**WEST SUSSEX COUNTY COUNCIL
INFRASTRUCTURE CONSULTATION**

SUBJECT: R/101/10

37 Woodlands Avenue, Rustington

Proposed garage and dropped kerb

BLOCK PLAN 1:500

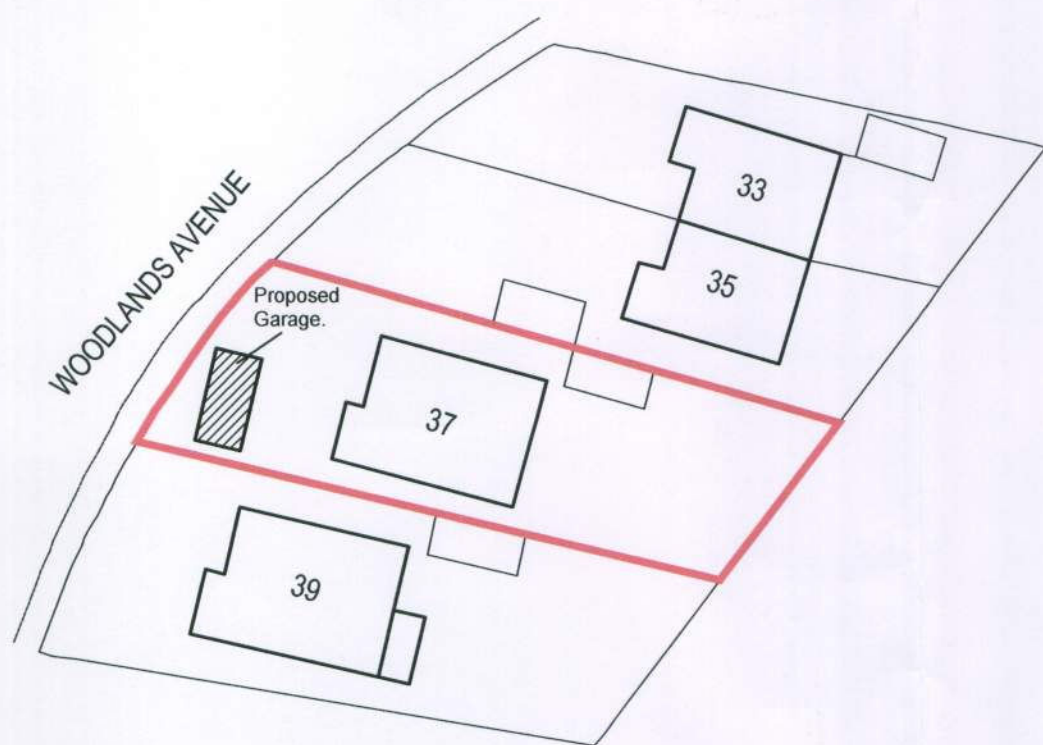
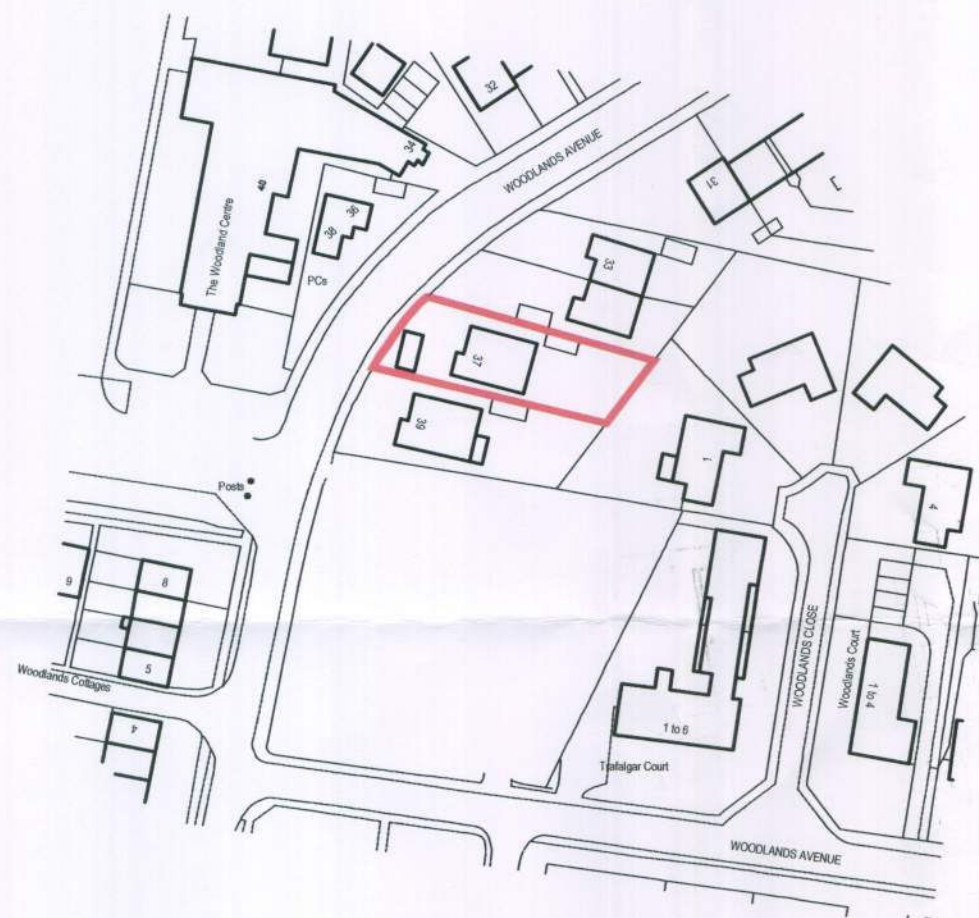
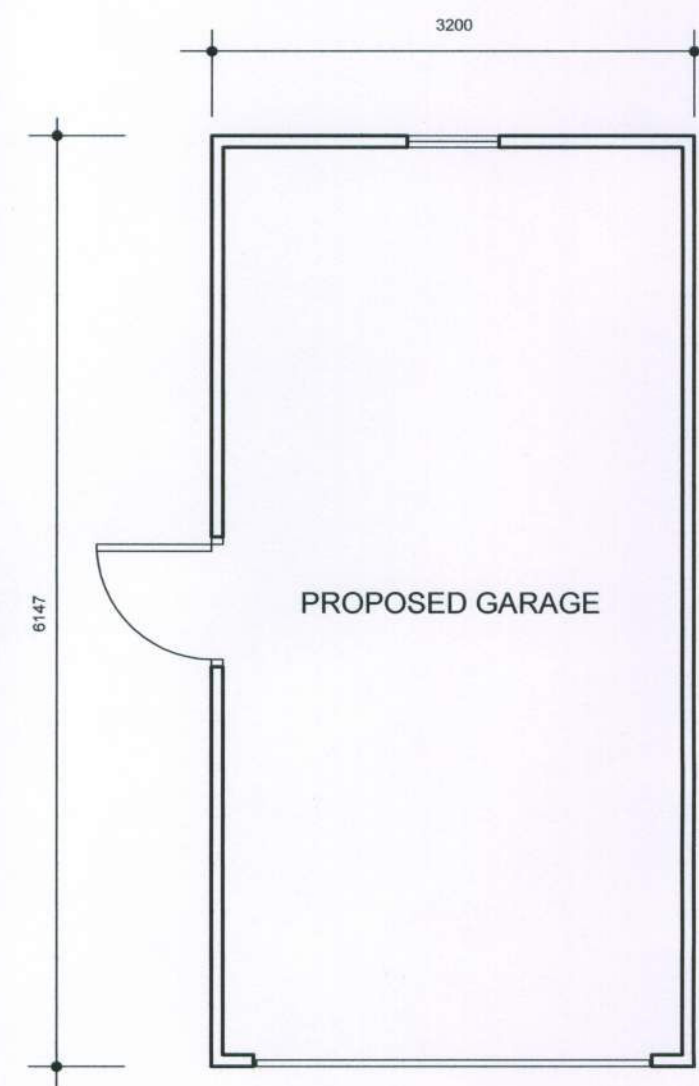
From an inspection of the plans alone the proposed garage appears to be too close to the carriageway of Woodland Avenue. The garage should be located a minimum of 6.0m from the carriageway in order to prevent vehicles obstructing the free flow of traffic whilst opening and closing the garage door.

WSCC has no highway safety concerns regarding the principle of the application, however it is recommended that the applicant modify the plans to conform to the above advice. If the LPA were minded to approve this application the applicant is advised to contact the Area Engineer, West Sussex County Council, Drayton Lane, Drayton, Chichester, PO20 6BW, (Tel no: 01243 642105) to obtain formal approval from the highway authority to carry out the site access works on the public highway.
